From: Sue Howell <Sue.Howell@arun.gov.uk>
Sent: 28 February 2020 14:58
To: Planning.Responses <Planning.Responses@arun.gov.uk>
Cc: Michael Eastham <Michael.Eastham@arun.gov.uk>
Subject: RE: Planning Consultation on BE/15/20/DOC

Application ref: BE/15/20/DOC

Description: Approval of details reserved by condition imposed under hybrid application ref BE/135/18/PL relating to Full Approval Condition Nos 3 - materials and external finishes of buildings in Phase 1, 4 - external lighting for any unit except Unit 2, 10 - **hard and soft landscaping**, 19 - badger survey, 21 - CCTV strategy Units 4-9, 30 - security fencing between Unit 8 & Units 6 & 7 and around Unit 9, 44 - 2.0m high bunding and 46 - existing & proposed ground levels, proposed finished floor levels, levels of paths & parking and proposed completed height of development.

Location: Land At Salt Box West Of Shripney Road Bognor Regis PO22 9NW

Full application Condition 10 - Units 4,5,6,7 & 8 Hard & Soft Landscaping

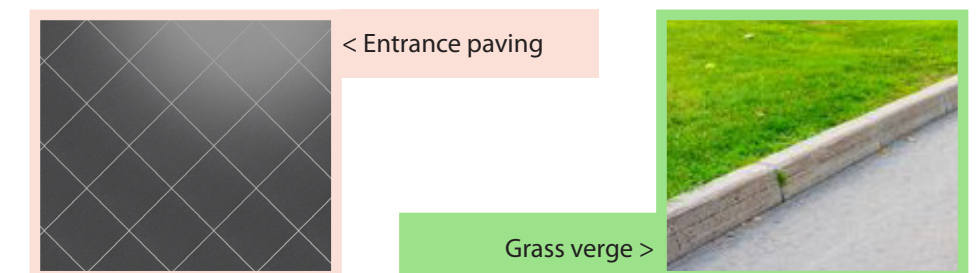
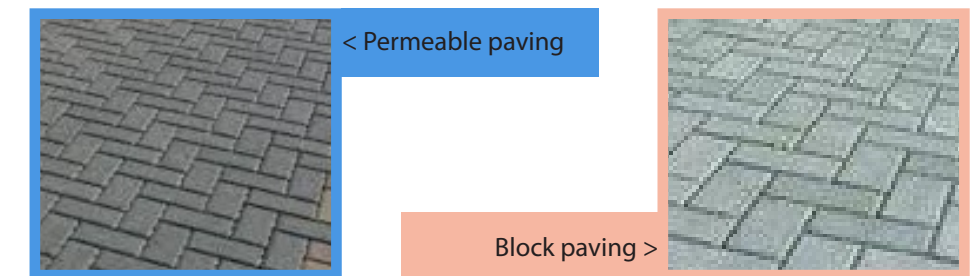
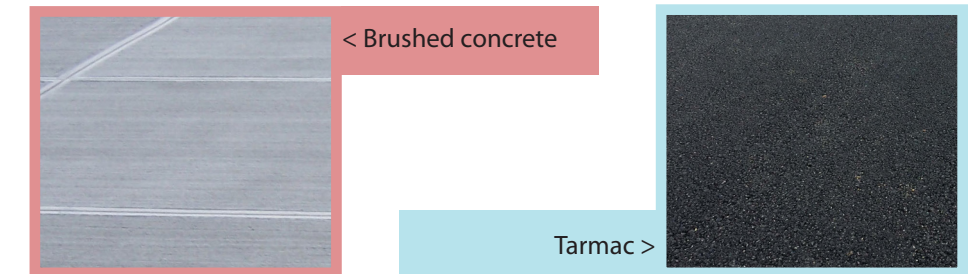
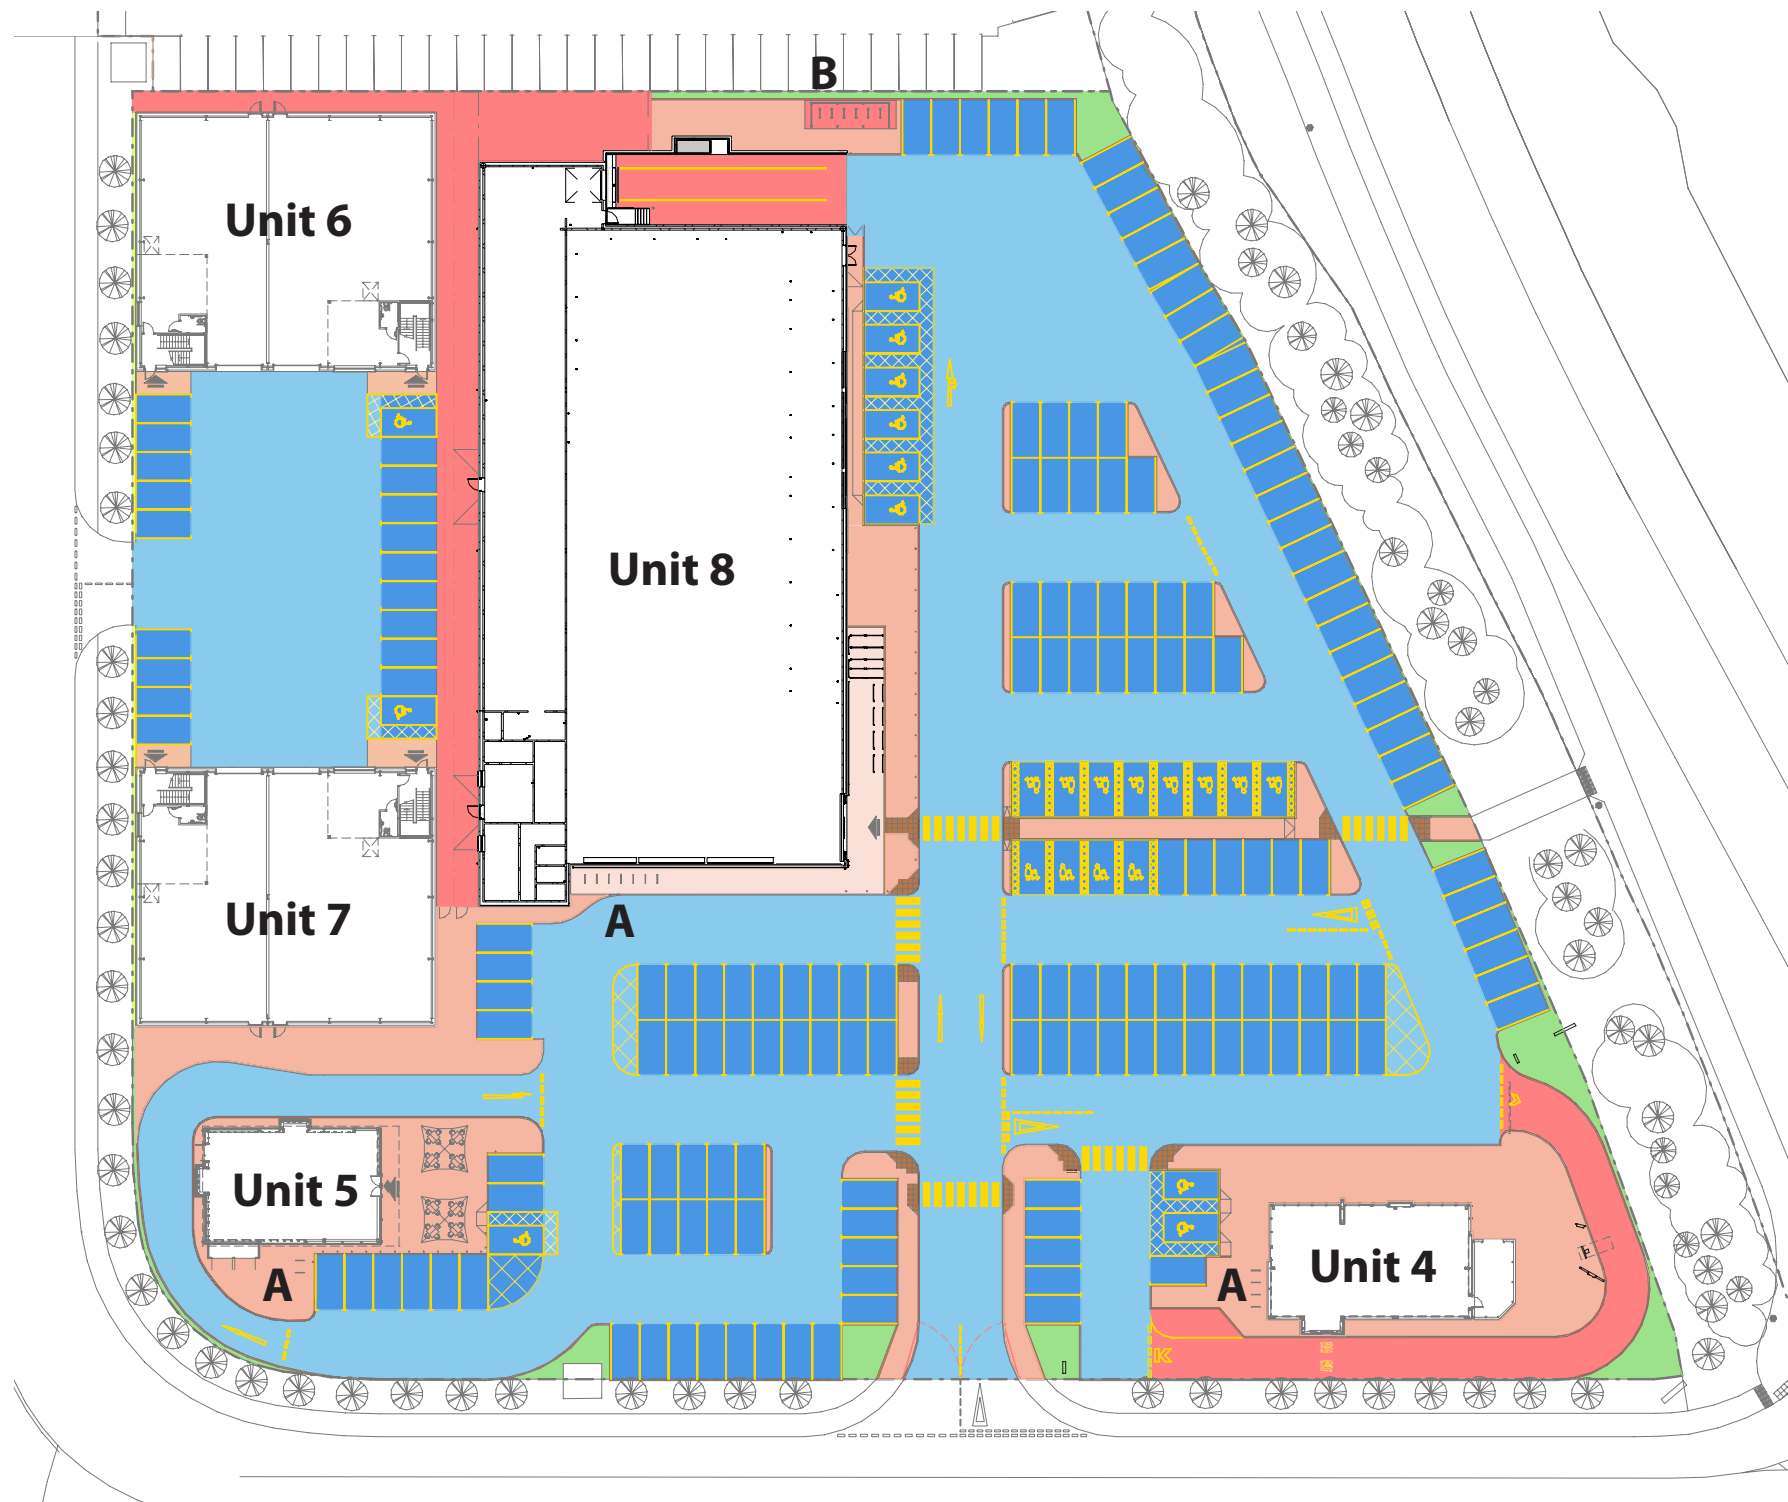
Following submission of Landscape proposals Saltbox Site Northern Bund Cross Section Detail dwg no 5920.CSD.10.0 Rec C I would advise that this drawing contains insufficient detail regarding plant species, actual quantities, planting densities and size at time of planting. Detail also submitted in Units 4,5,6,7,8 hard and soft landscaping dwg also contains insufficient soft landscaping detail.

I would **not recommend the discharge of Condition 10** imposed under hybrid application ref BE/135/18/PL until further detail above has been submitted for approval.
